DELEGATED HOUSEHOLDER DECISION

The application proposes the conversion of roof space to habitable use including raising the ridge height and alterations to roof profile with 2 x rear dormers and 3 x front roof lights.

48 MYRTLE AVENUE RUISLIP

PROPOSED FRONT ELEVATION

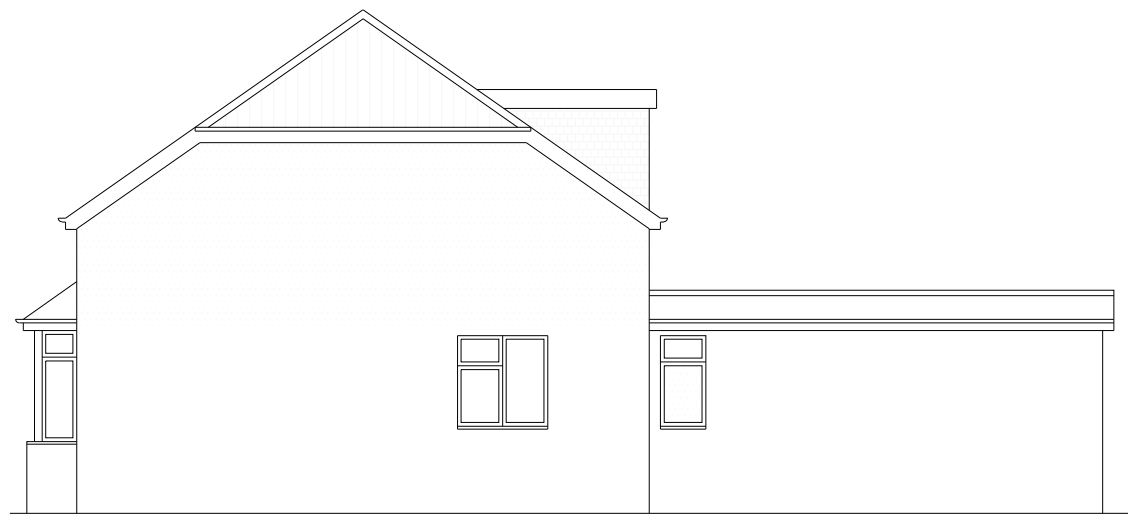
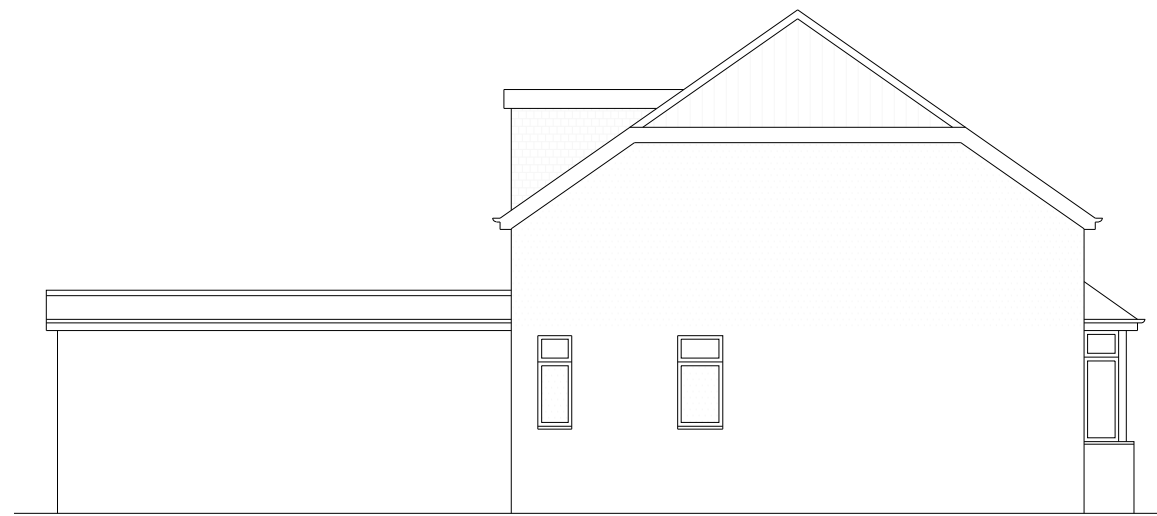
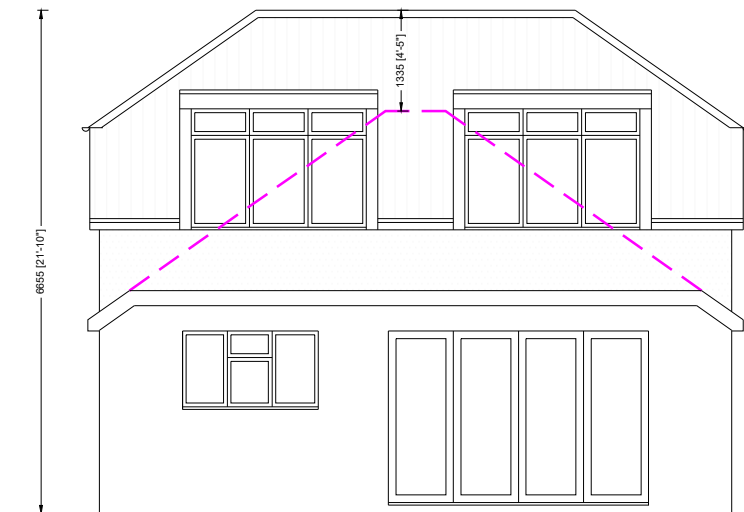
The application is proposing a conversion of roof space to habitable use including raising the ridge height and alterations to roof profile with 2 x rear dormers and 3 x front roof lights. The proposed roof extension would create a new storey to the main dwelling with two new habitable rooms on the new first floor. The new roof form would be a mansard style with gable ends. The roof increase in height from the eaves would be approximately 1.33m.

In addition, No.45 is sited in between a two storey dwelling to the east and a bungalow to the west and acts as a transition in height. In comparison, the application site is located in the middle of two bungalows which are of a similar height to the existing dwelling. As a result, the proposed increase in height and alterations to the roof profile would be incongruous.

The proposed rear dormers windows are not subservient and do not respect the window hierarchy of the dwelling, creating a top heavy and poorly designed proposal which would substantially alter the appearance of the property, visible from multiple public and private view points.

Moreover, the roof alterations, when viewed as a whole, would appear out of character with the surrounding area, where the vast majority of bungalow properties have retained their hipped roof forms, some with a distinctive gable feature to the front. It is noted that no other property has been extended in such a manner, and the proposed mansard roof and eaves height would compete with and detract from the existing modest roof profile. In this context, it is considered that the roof form would result in an incongruous and insubordinate development that fails to respect the character of the area. Therefore, the significant increase in the overall size, prominence, scale, bulk and massing of the host dwelling would result in a development that would not appear subordinate and out of character.

Therefore, it is considered that the proposed development, when viewed as a whole, would be completely disproportionate, overly prominent and unsympathetic to the original architectural composition of the host dwelling, resulting in the proposed development having a harmful impact to original dwelling, and the character, appearance and visual amenities of the area. The proposal would therefore conflict with Paragraphs 130b) and 134 of the National Planning Policy Framework (2021), Policies D3 and D4 of the London Plan (2021), Policy BE1 of the Hillingdon Local Plan: Part One Strategic Policies (2012) and Policies DMHB 11, DMHB 12 and DMHD 1 of the Hillingdon Local Plan: Part Two - Development Management Policies (2020).
